PL- Consultation- Updated Ecology response.

Y/5/26/PL

From: Jonathan Best <Jonathan.Best@arun.gov.uk>
Sent: 02 April 2026 15:43
To: Planning.Responses <Planning.Responses@arun.gov.uk>
Cc: Hebe Smith <Hebe.Smith@arun.gov.uk>
Subject: Updated ecology comments

2 Downview Road Yapton BN18 0HS.

**2 Downview Road, Yapton :
Proposed Site for new Dwellinghouses :
Existing Habitats**

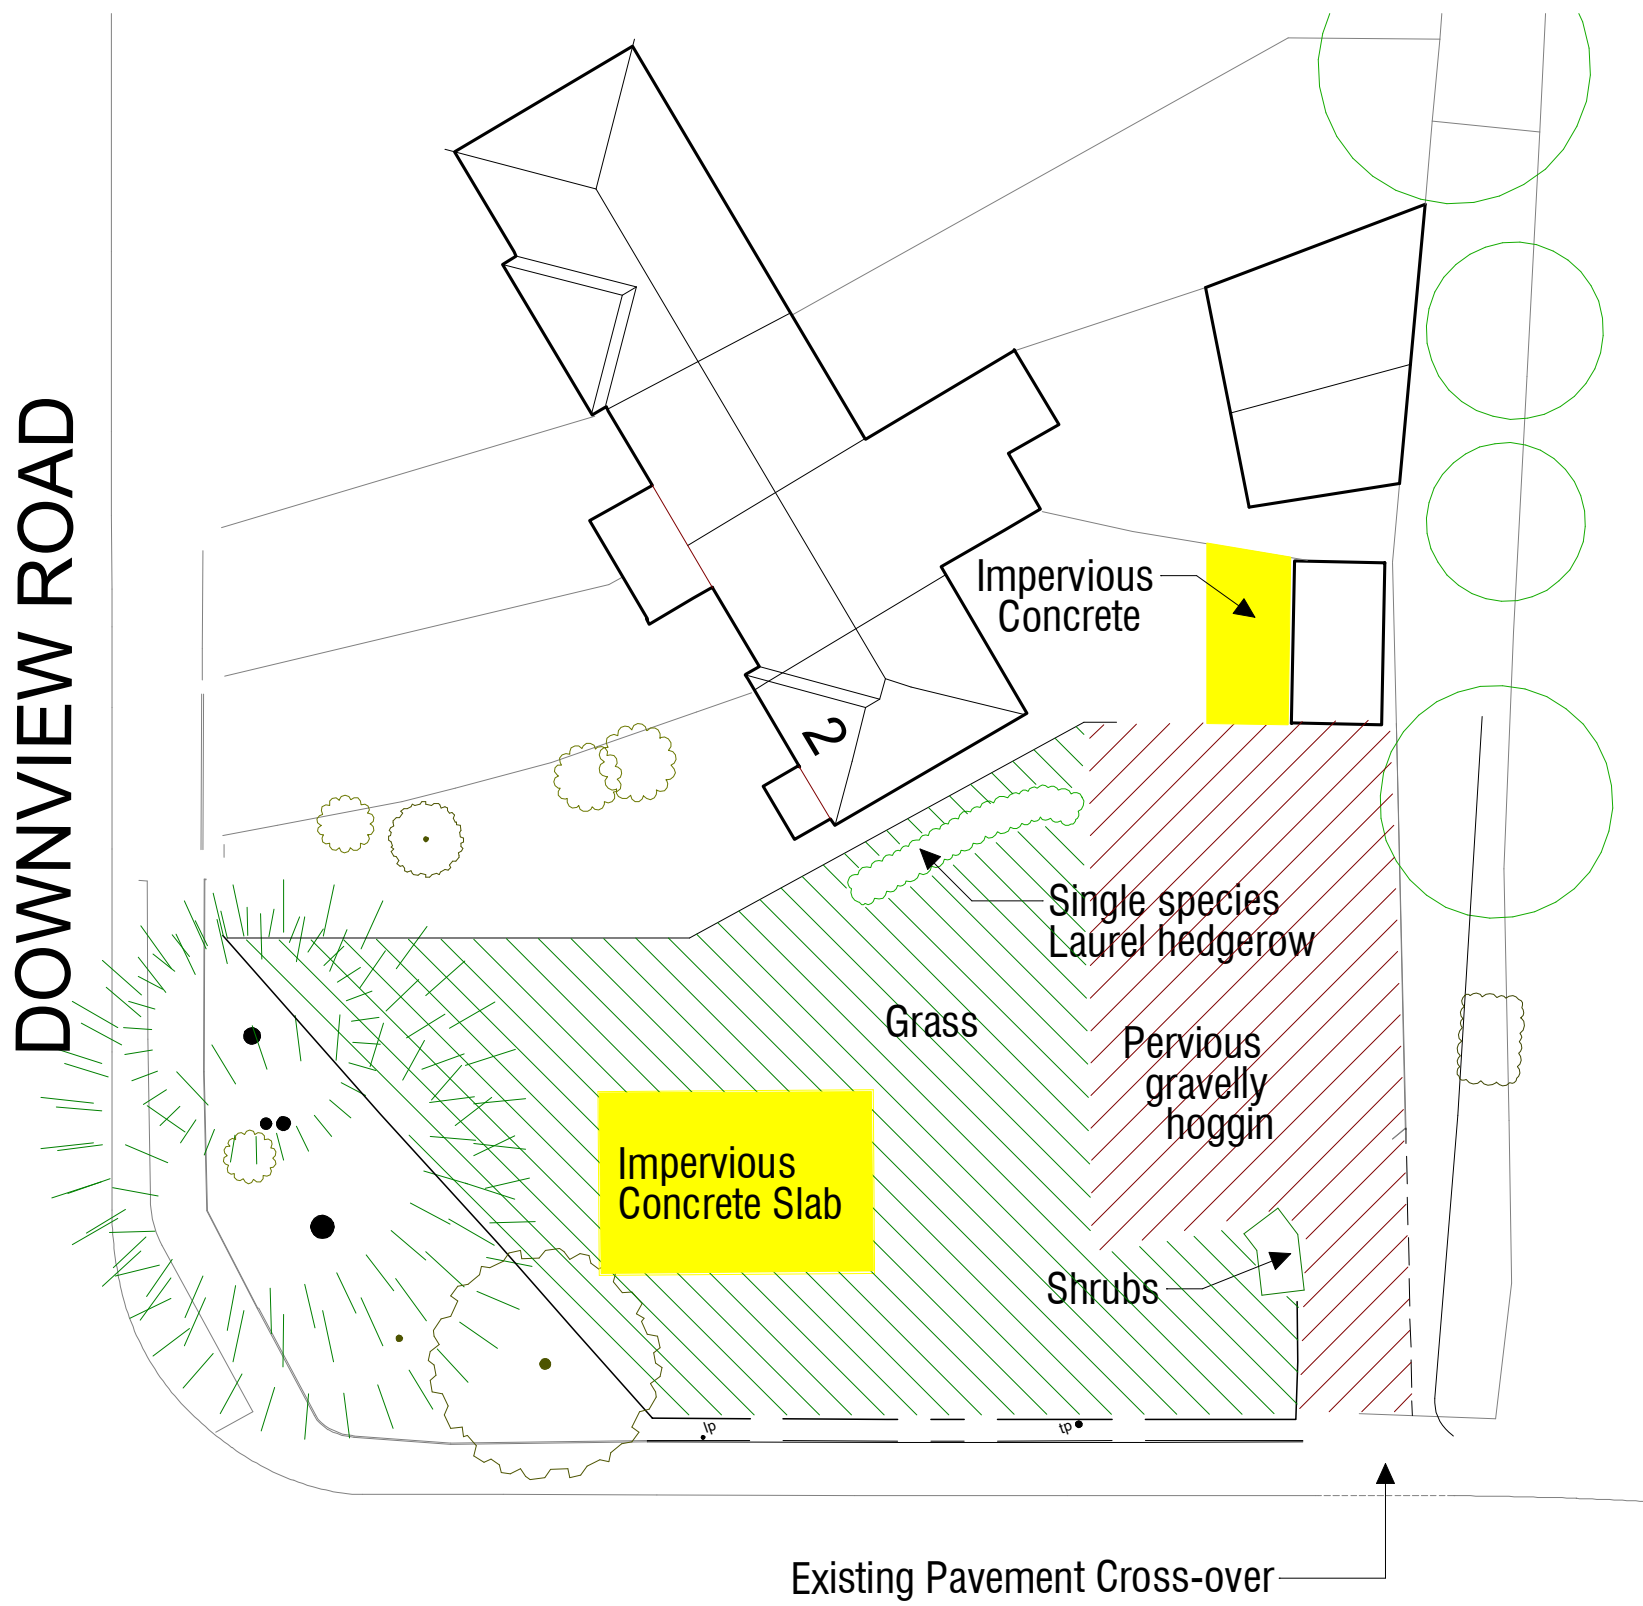
Ariel imagery shows the site had a line of mature trees present in 2024 on the southern boundary, but these have since been removed. Habitat present in January 2020 should be counted in the metric even if it is no longer present. This will change the baseline for habitats and may show a greater loss of biodiversity units. The baseline habitat value may be incorrect. Clarification on this is recommended.

Figure 2. Proposed development habitat map, with additional recommendations to meet required BNG targets.

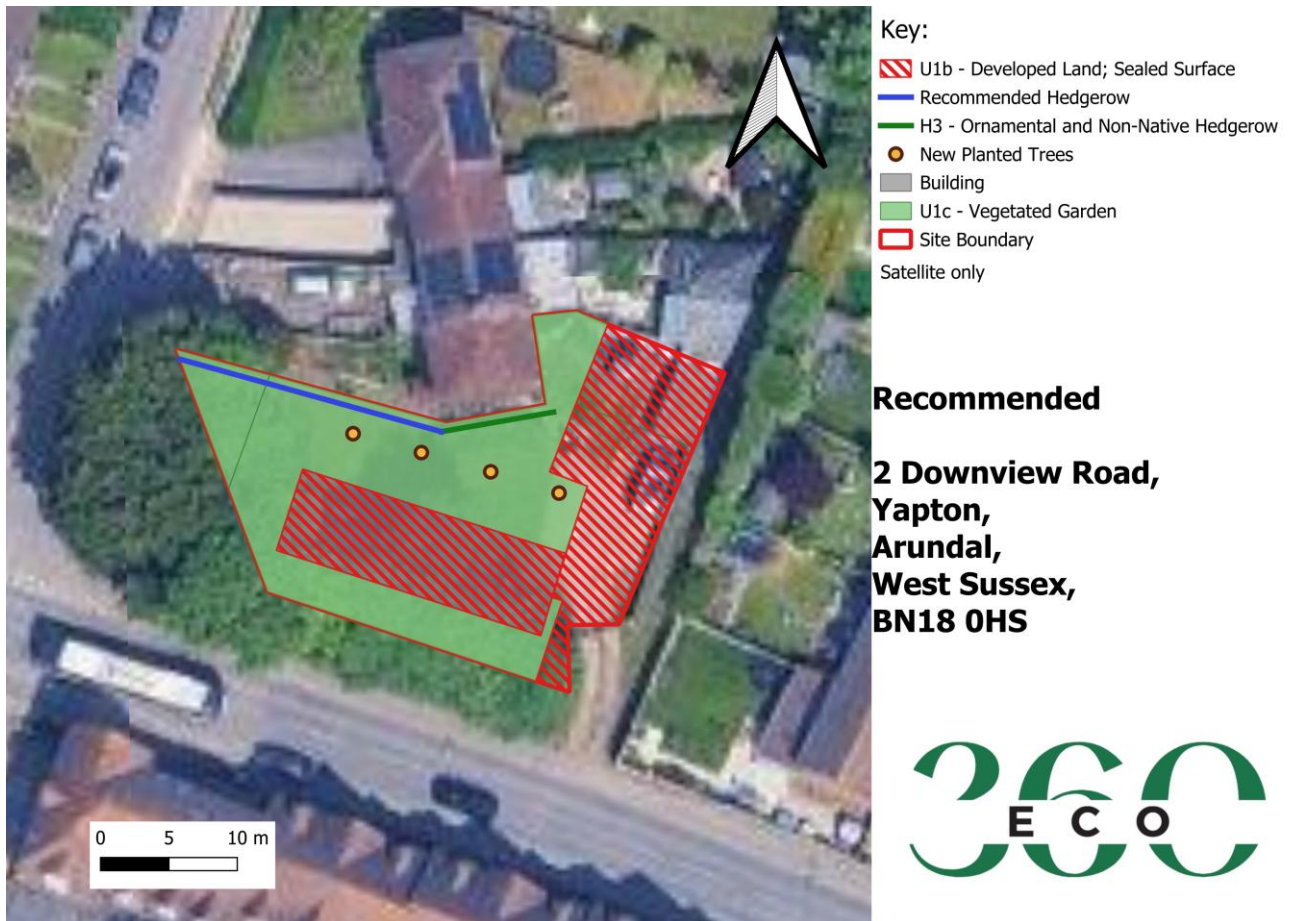
The provision of hedge and tree planting is welcomed but cannot count towards biodiversity as they are located within a private garden.

Therefore, the proposed gains recorded are incorrect for this application.

If the application is approved the errors with the baseline habitat and post development values will require rectification before we can discharge the biodiversity gain plan. Offsite habitat and hedge units are likely to be required to achieve the minimum 10% BNG.
